Application Ref:	3/2026/0113			 Ribble Valley Borough Council www.ribblevalley.gov.uk
Date Inspected:	26/03/26	Site Notice:	26/03/26	
Officer:	LW			
DELEGATED ITEM FILE REPORT:				REFUSAL

Development Description:	Proposed construction of phase 2 of a poultry house to accommodate 16,000 free-range chickens for egg production.
Site Address/Location:	Wheatley Farm, Four Acre Lane, Longridge, PR3 2TD.

TITLE  
**OS Map & Block Plan**

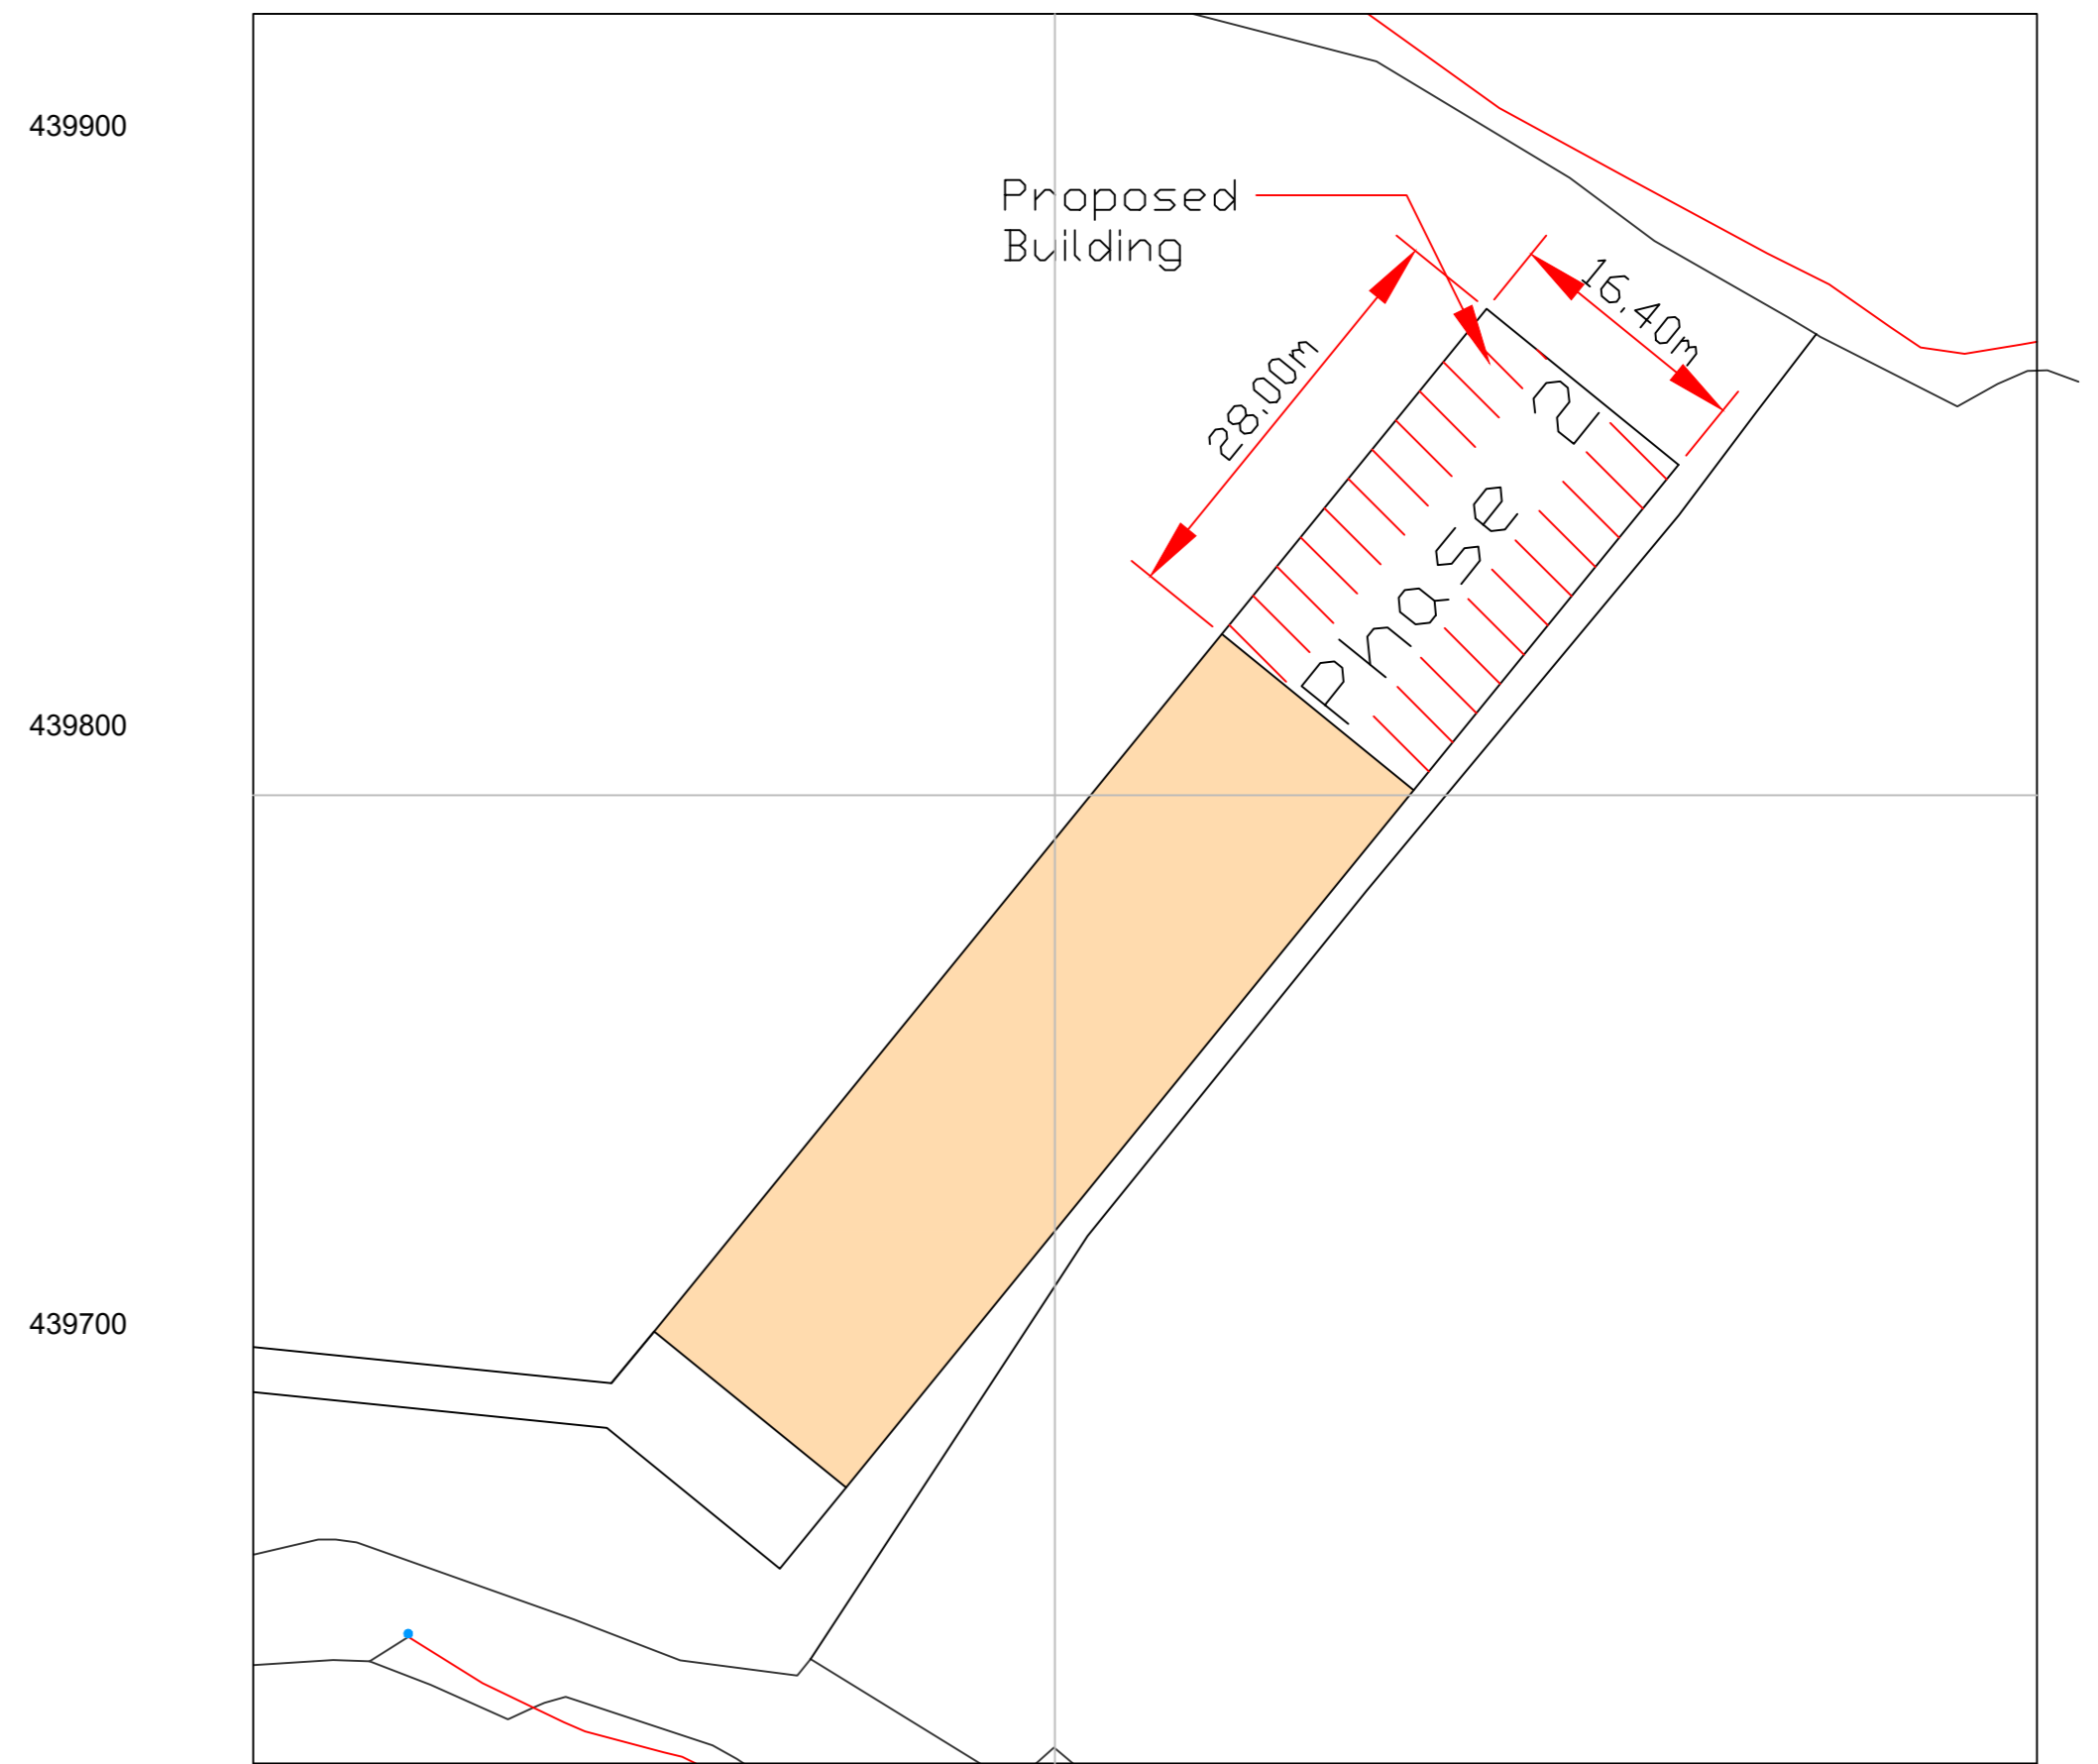
'Whilst the proposed building would incorporate traditional agricultural materials, including green box profile tin, the development would comprise a significant footprint and would be detached from the existing cluster of agricultural buildings, instead being sited within the adjacent open agricultural field. The siting of the proposed building, combined with the size of the development, would therefore result in an incongruous addition to the surrounding landscape.'

TITLE  
**Proposed Elevations & Layout To Accommodate A Proprietary  
Free Range Poultry Unit. – Phase 2 Agricultural Building.**

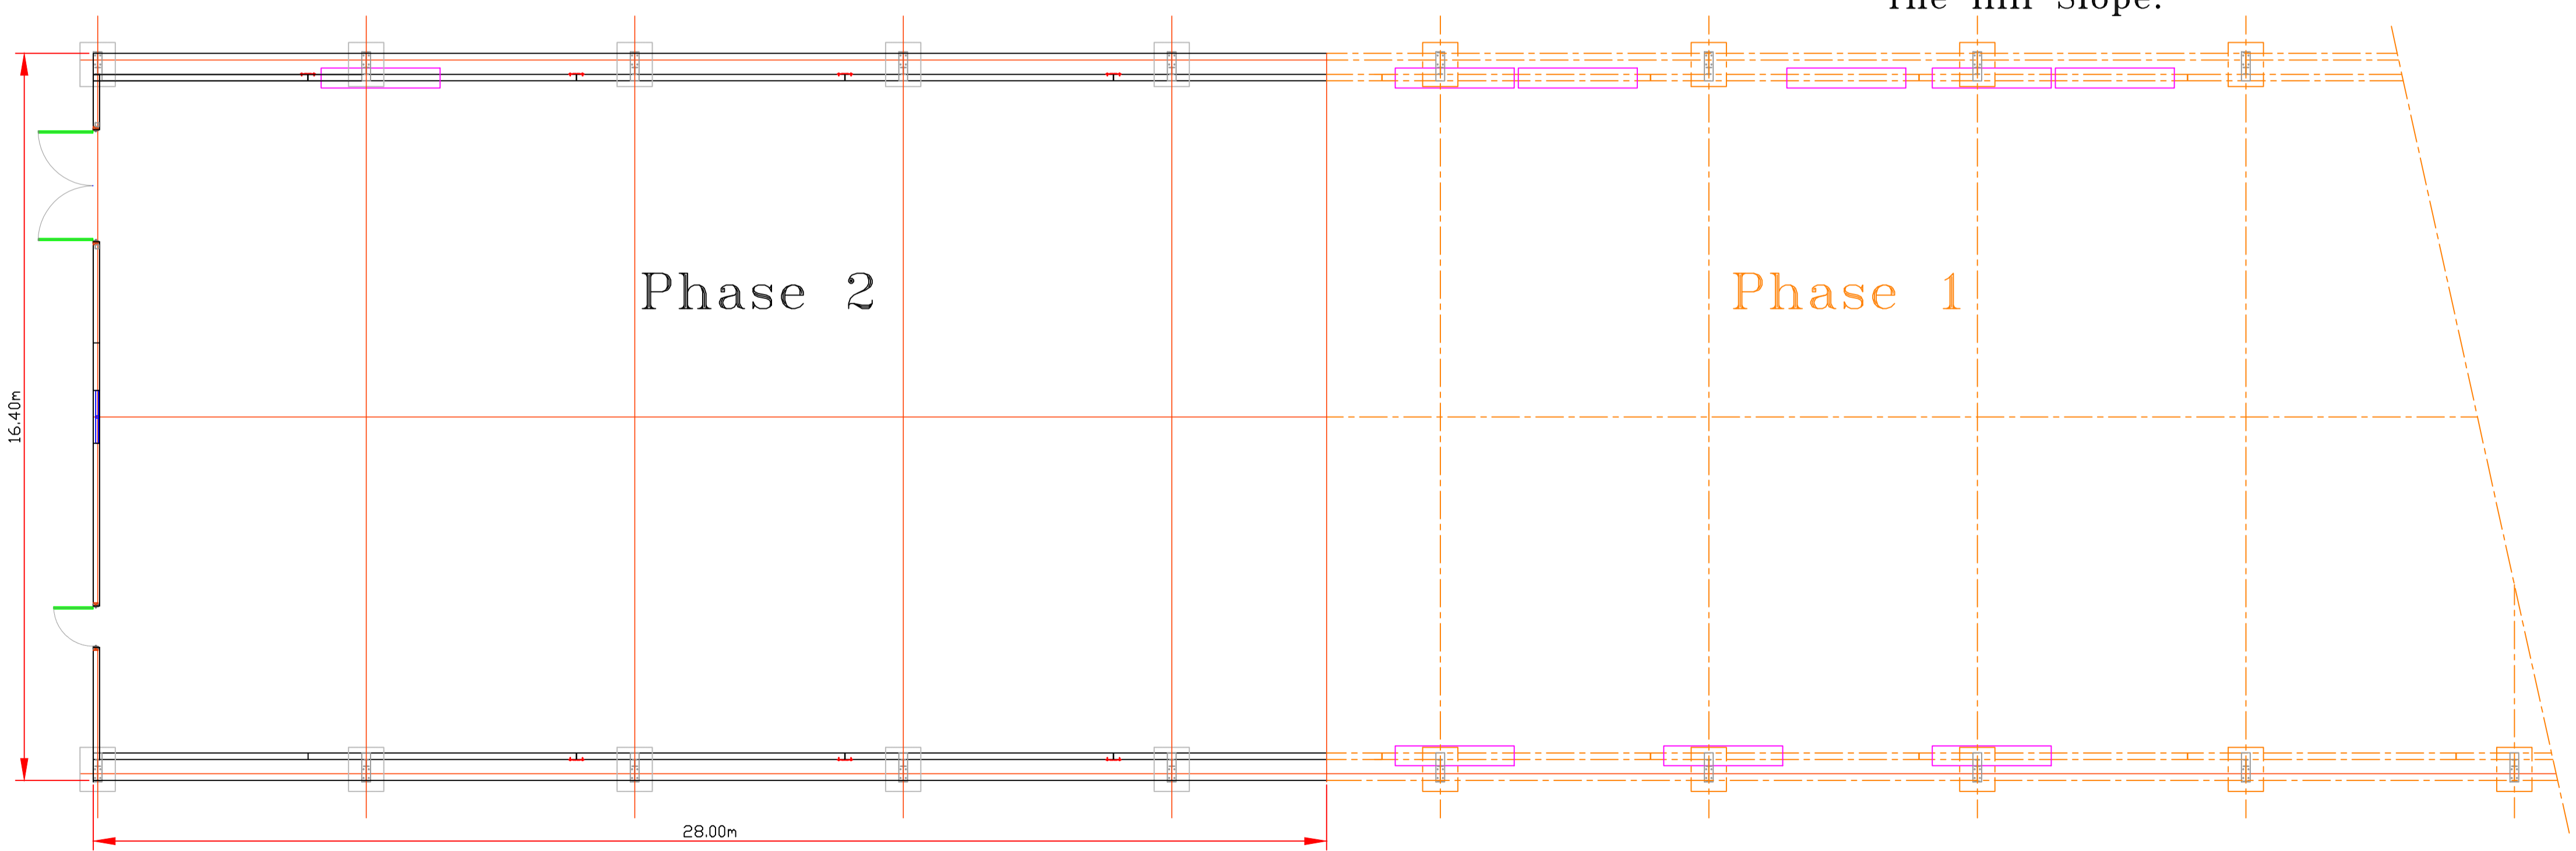
It is considered that the proposed development would result in a change to the character of the rural landscape. Phase 1 of the proposed poultry house (applied for under 3/2026/0112) would comprise a significant footprint measuring 60m by 16.4m, with Phase 2 of the building increasing the building by a further 28m to create a poultry house with a total floor area of 1,443 square metres and height of 5.6m.

Whilst it is noted that the total length of the building (inclusive of Phase 1 and Phase 2) has been reduced by 2m, the width and height of the proposal has been increased from 10m to 16.4m and 4m to 5.6m respectively, resulting in a larger overall building than that original proposed under the refused prior approval application. The building is also to be sited in the same location and as such, the concerns raised under 3/2025/0099 remain, insofar that the extent of cumulative built form which would result from the implementation of both Phase 1 and Phase 2 is considered to result in significant harm to the landscape character within the Forest of Bowland National Landscape by way of loss of openness.

The construction of the proposed poultry house would result in a significant addition to an open agricultural field within the Forest of Bowland National Landscape which would be of such a size and scale that it is considered to result in harm to the special qualities of the National Landscape.
